Please ask for: Ms Iqraa Malik
Email: iqraa.malik@terraquest.co.uk
Telephone: 01212341390
Our Ref: R/206/21/HH
Your Ref:
Date: 17th August 2021

Application for Planning Permission for Works or Extension to a Dwelling

Development: Replacement Porch
Location: 1 Ingram Close Rustington BN16 3NZ

PROPOSED BLOCK / ROOF PLAN 1:200

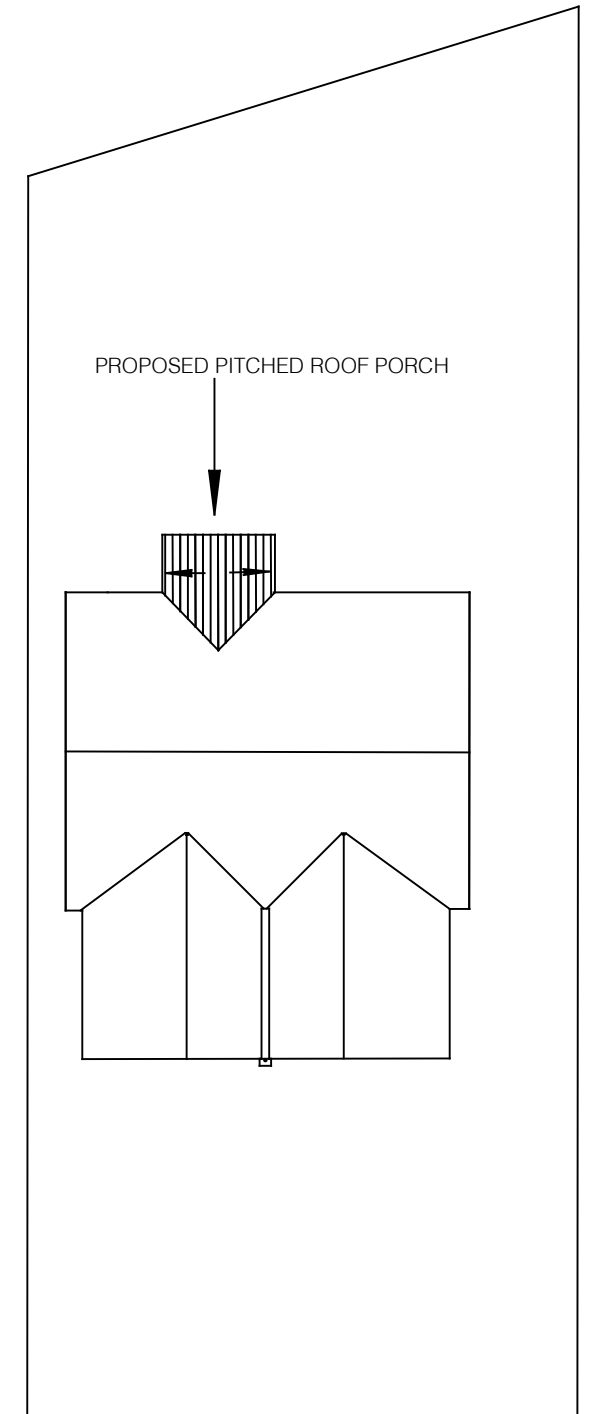
Block Plan

You are required to have dimensions from the proposed extension(s) to all site boundaries. Please amend.
